CITY OF ALBUQUERQUE

August 17, 2020

**Re: Pascetti Steel Building
2114 Claremont Ave. NE
Traffic Circulation Layout
Architect's Stamp 08-10-20 (H16-D021)**

TCL
SHEET NO
A1.2

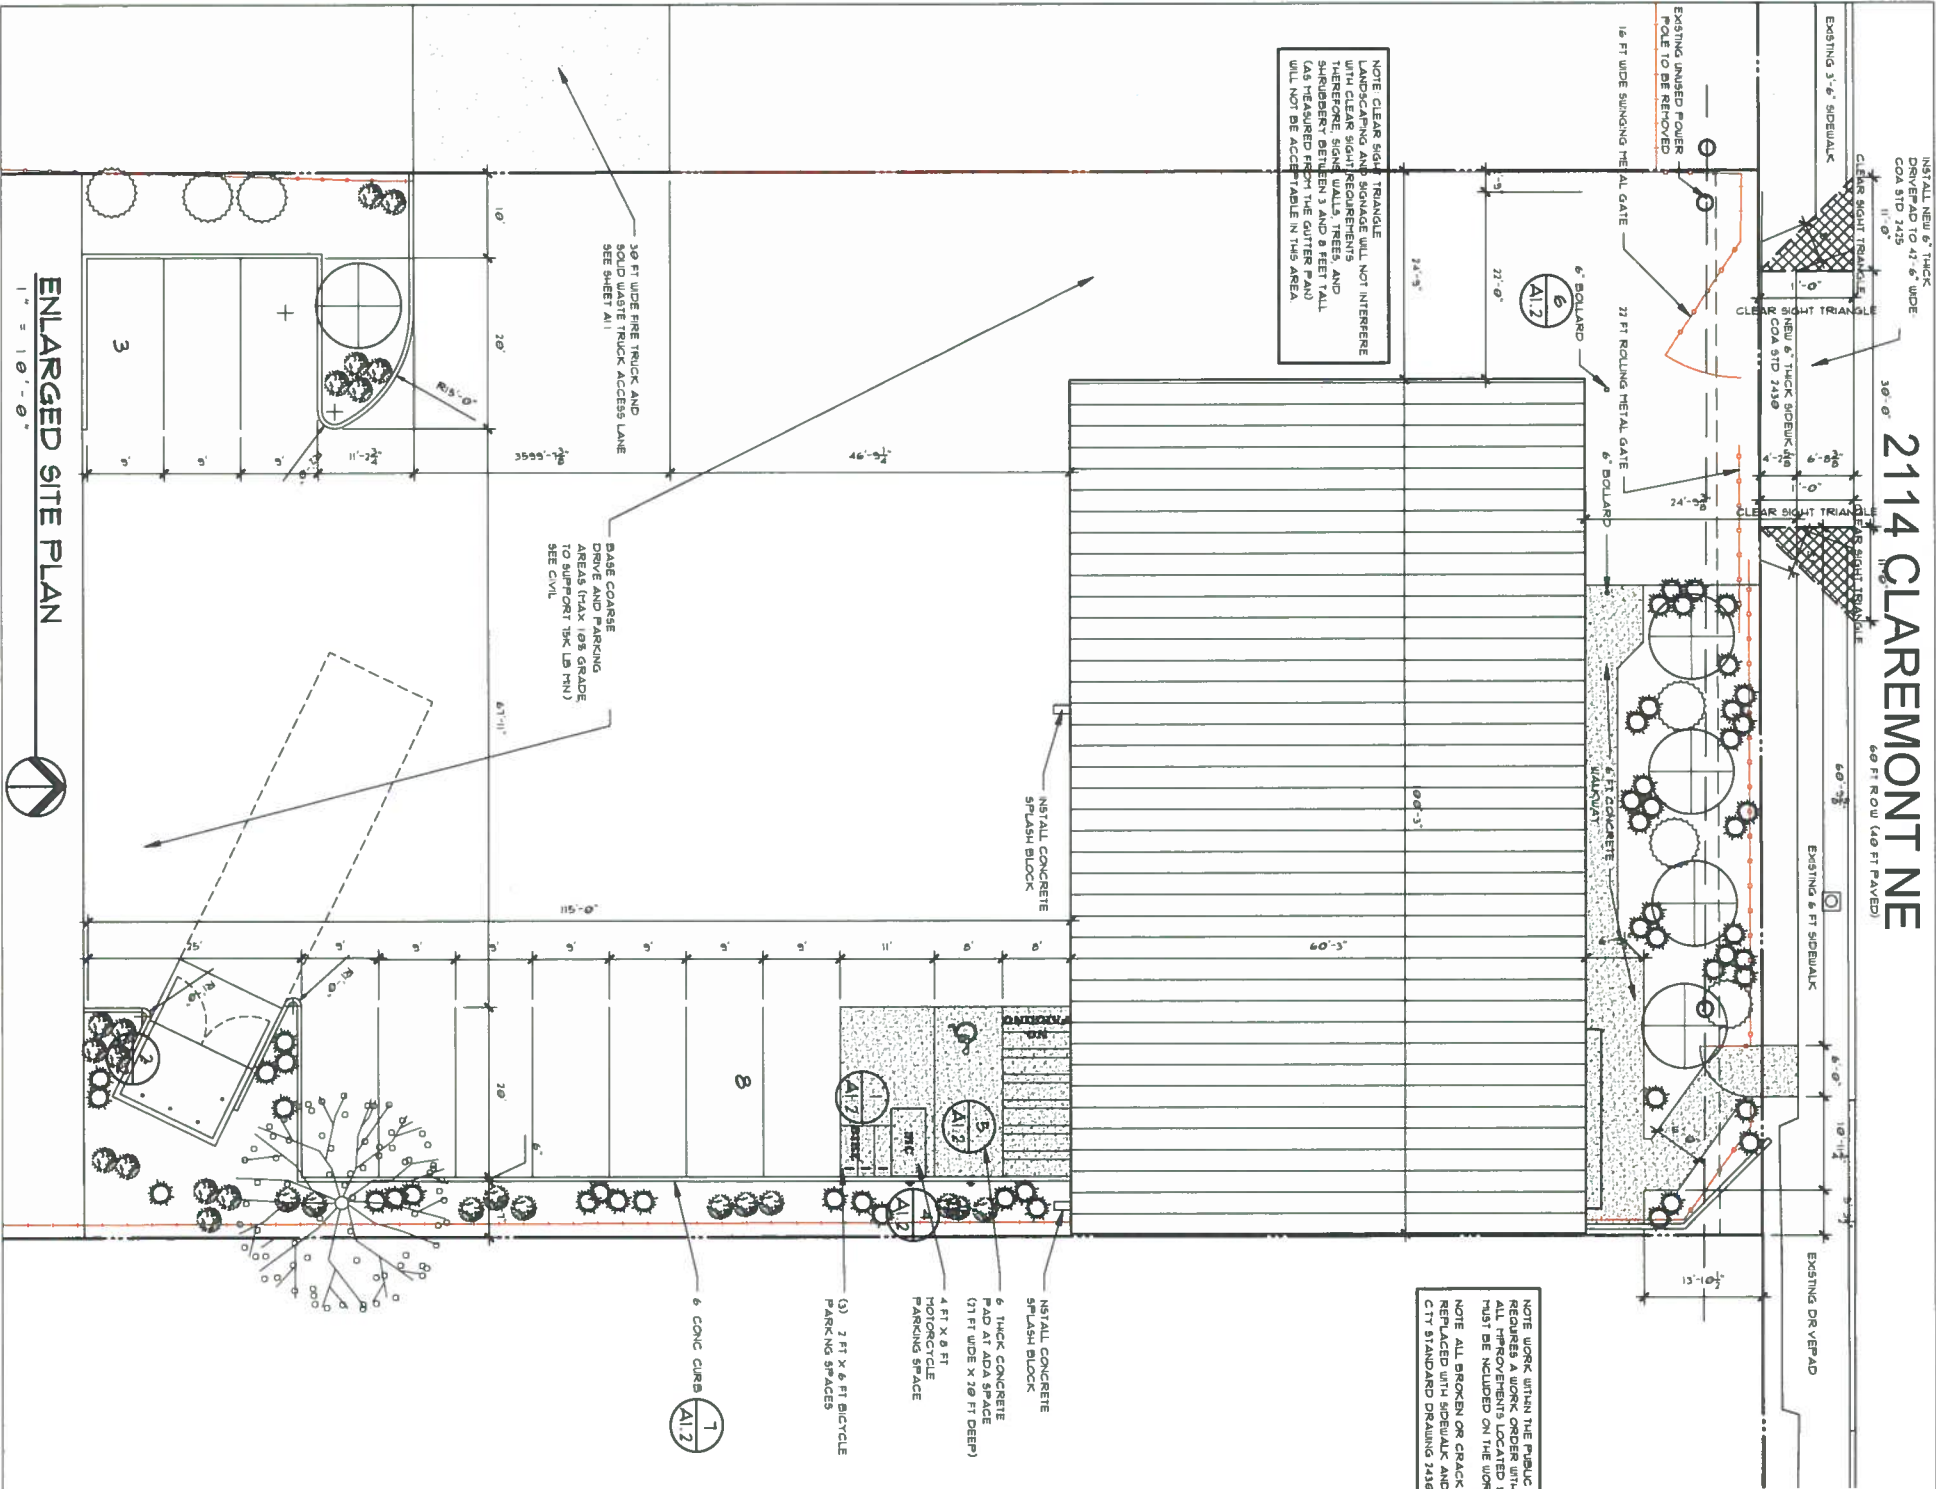
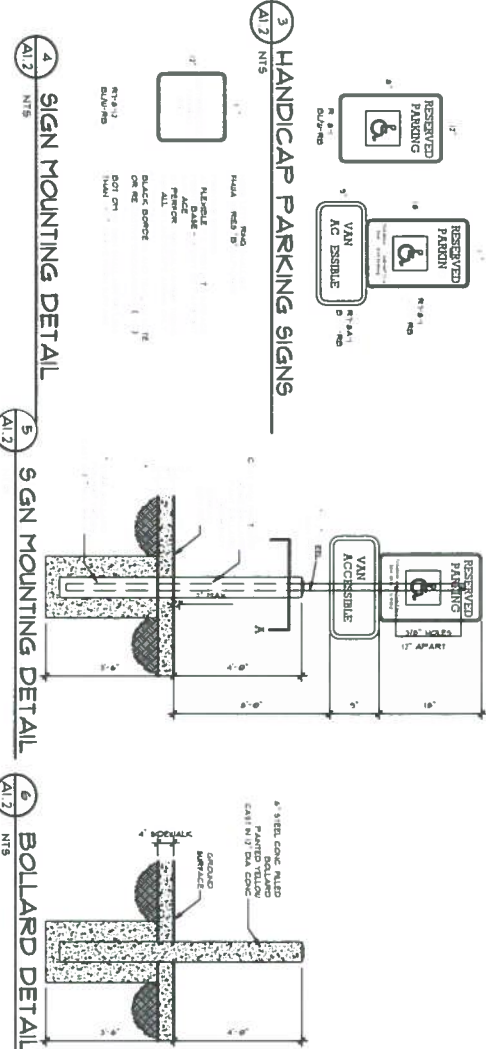
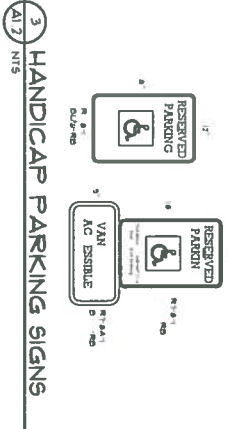
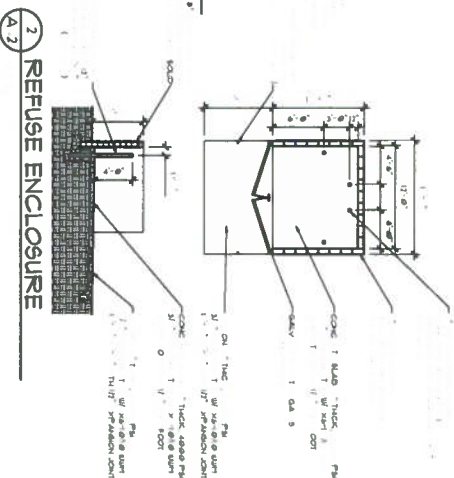
1. Maximum access width for arterial, collector, and **local streets (Claremont Ave.)** are as follows:

Arterial& Collector	Local Streets
One-way Drive	20'-25'	12'-20'
Two-Lane Drive	22'-30'	22'-24'
Three-Lane Drive	24'-35'	22'-30'
Larger Vehicles	≤50'	≤30'

THE MAXIMUM ALLOWABLE WILL entrance width BE 30 FT., please reflect this on your plans

2. The proposed 43'-9" (30 ft will be accepted-only) driveway sidewalk 4 ft width encroached onto the western land owner and will need this landowners approval for the encroachment and/or **an approved letter specifying the landowner is in agreement.**
3. Shared Site acces: driveways that straddle property lines, or are entirely on one property but are to be used by another property, shall have an access easement. Please include a copy of your shared access agreement with the adjacent property owner. PLEASE: **PROVIDE ACCESS AGREEMENT BETWEEN 2110 AND 2114 CLAREMONT.**
4. Unused curb cuts must be replaced with sidewalk and curb & gutter. A build note must be provided referring to the appropriate City Standard drawing (**This**

applies to the existing drivepad on the eastern corner of property). There appear to be passage through this property and adjacent property to the east, Is there an existing share access easement? **Please address this concern: Provide a letter from Owner, Pascetti Clarement, LLC. That agrees to continuing allow aces to drive pad on the north east corner for access to adjacent property.**

5. Add a note stating "All broken or cracked sidewalk must be replaced with sidewalk and curb & gutter." A build note must be provided referring to the appropriate **City Standard drawing (2430 & 2415).**
